HINCKLEY NATIONAL RAIL FREIGHT INTERCHANGE

Project reference TR050007

Applicant's response to Deadline 7 Submissions [part 6- Non-Statutory Bodies]

Document reference: 18.21

Figure 6: Proposed ANPR Camera Locations

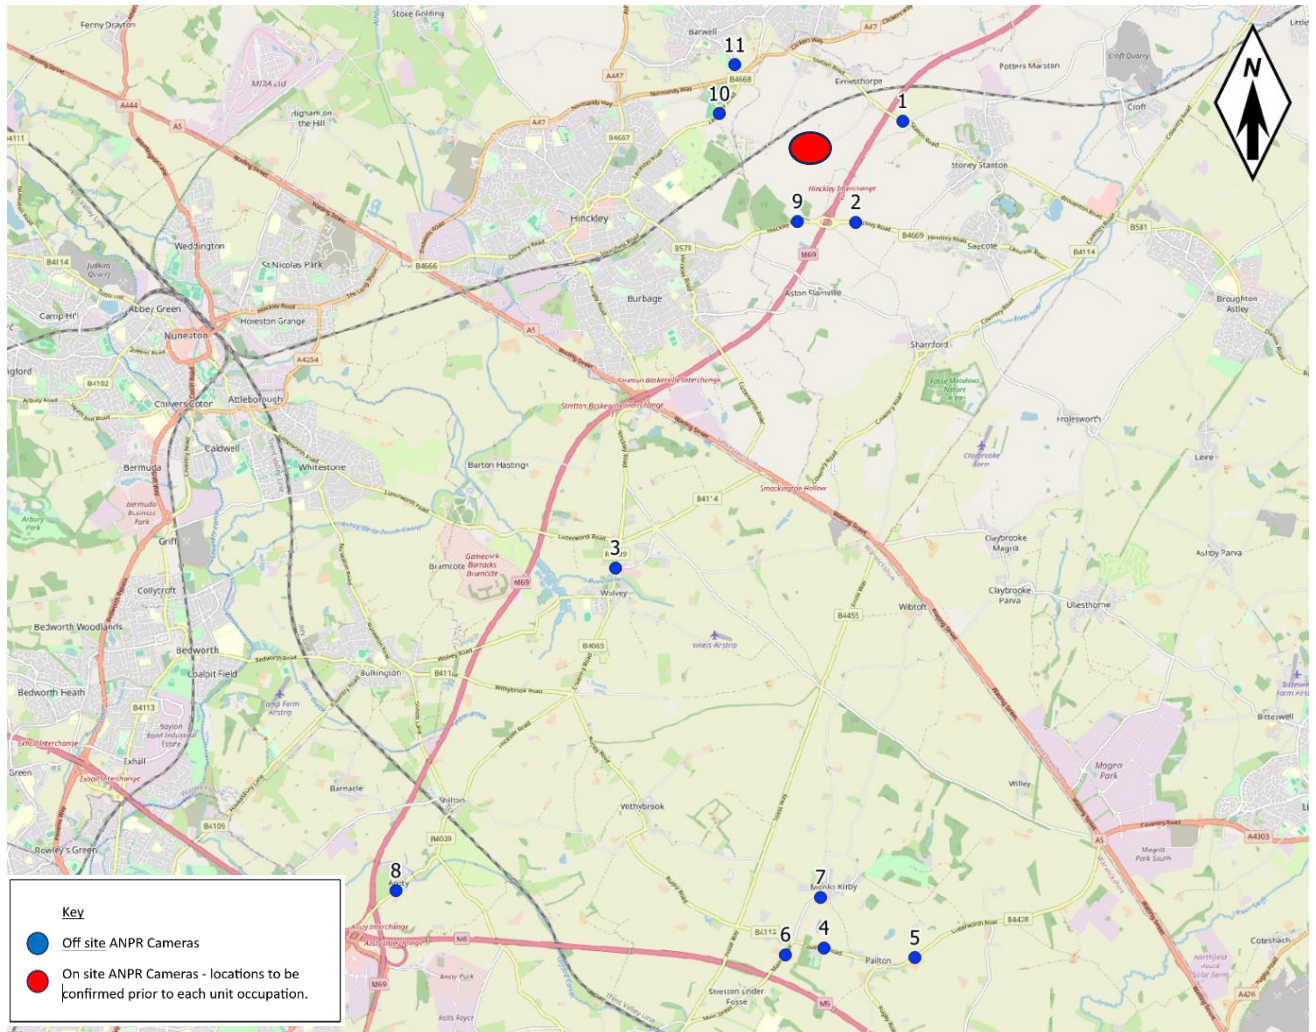
2.16	Note: We welcome the addition of the New RMS Figure 6: 'Proposed ANPR Camera Locations' which identifies (as requested by the Panel) the locations of the cameras. It underlines our comments at Deadline 6 (para 2.5-2.6) that only camera 2 can measure HGVs going towards Sapcote and its location may allow for debate about their onward route.	The camera locations pick up key movements through Stoney Stanton on the B581 and Sapcote on the B4669. The ANPR cameras will need to be situated in public highway and the details of their implementation (precise location, power supply, signage etc) will be subject to approval by Leicestershire and Warwickshire County Councils and consultation with relevant Parish Councils through details to be submitted to the LPA for Requirement 18.
	Para 5.1 response:
